**WELWYN HATFIELD BOROUGH COUNCIL  
EXECUTIVE DIRECTOR - PLANNING, PUBLIC PROTECTION AND GOVERNANCE**

**Application No:** 6/2018/1977/FULL  
**Location:** 4 Maynard Place Cuffley Potters Bar EN6 4JA  
**Proposal:** Change of use from retail (A1) to a mixed use retail and beauty salon (A1 and Sui Generis)  
**Officer:** Mr Richard Sakyi

**Recommendation:** Refused

Proposed Ground Floor Plan

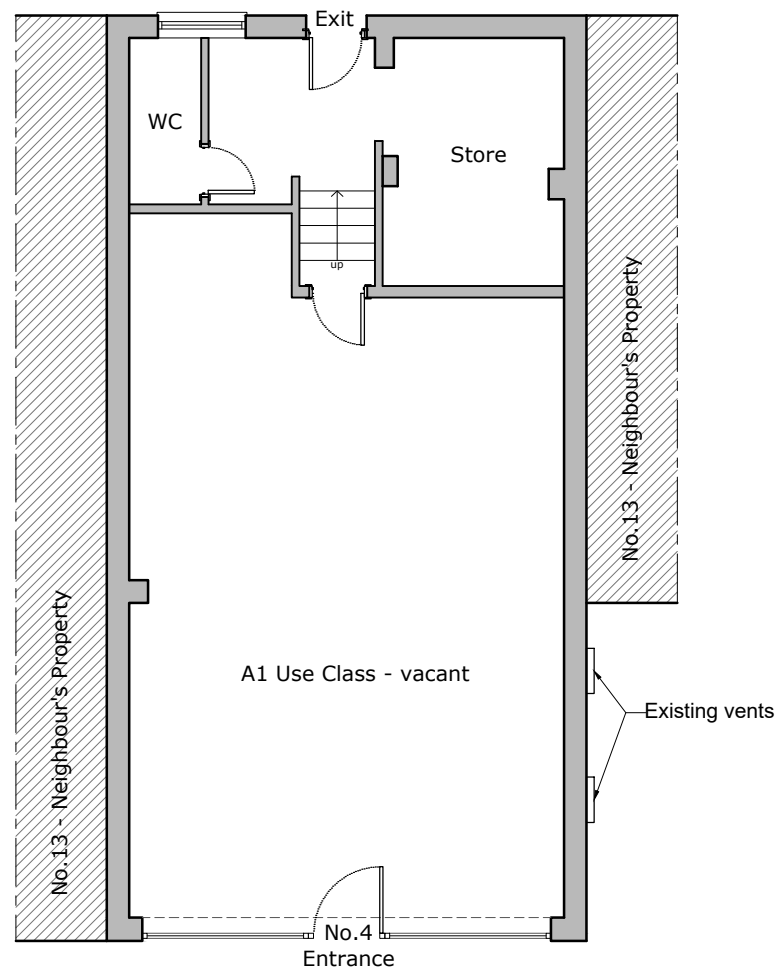
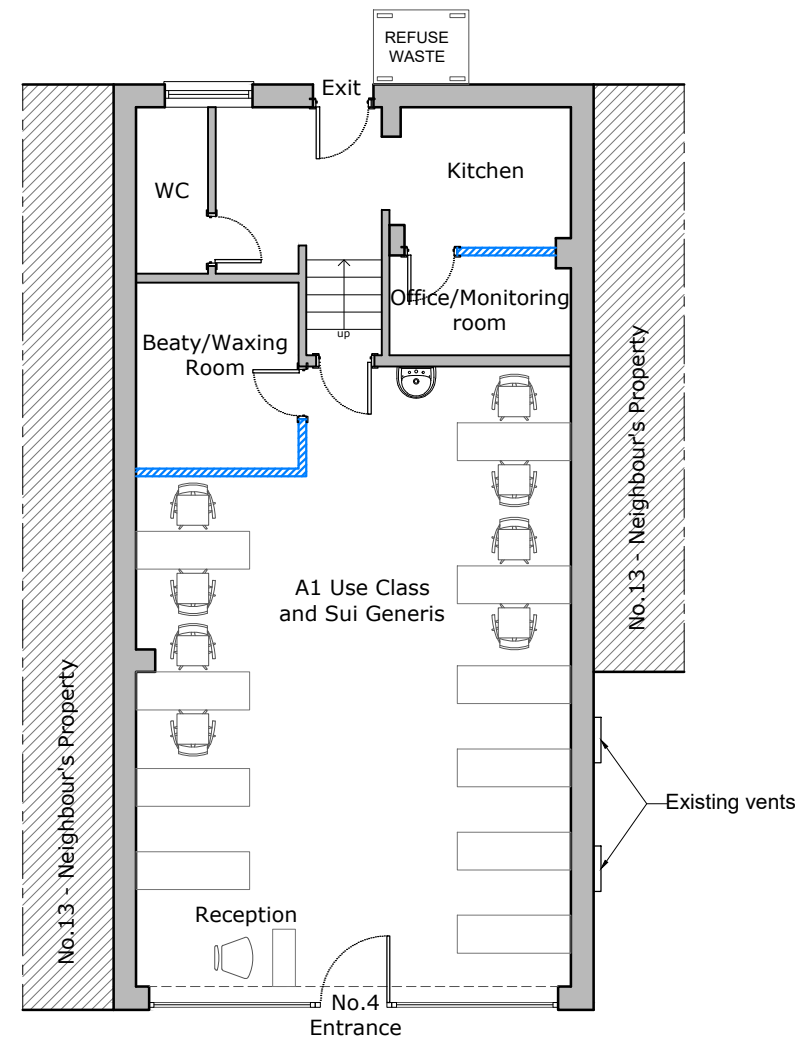
The applicant has indicated that the front part of the unit will be furnished with shelving displaying beauty products for sale; to the rear of the unit will be a WC, kitchen and office/monitoring room; and between there would be one small room for beauty/waxing treatment and four tables for beauty treatments. The Council is not convinced that the layout of the furniture in the unit would result in a true mixed use as proposed by the applicant, but instead the retail element would be ancillary to the primary use of the unit as a beauty salon. In arriving to this conclusion, the Council has considered the submitted floorplan showing four tables for beauty treatments, as well as the treatment room; and the submitted Design and Access Statement in which the applicant has indicated that there would be seven full-time equivalent employees. This number of employees is considered to be far in excess of what would reasonably be required for a retail use, suggesting that the main offer and function of the business would be the provision of beauty treatments.
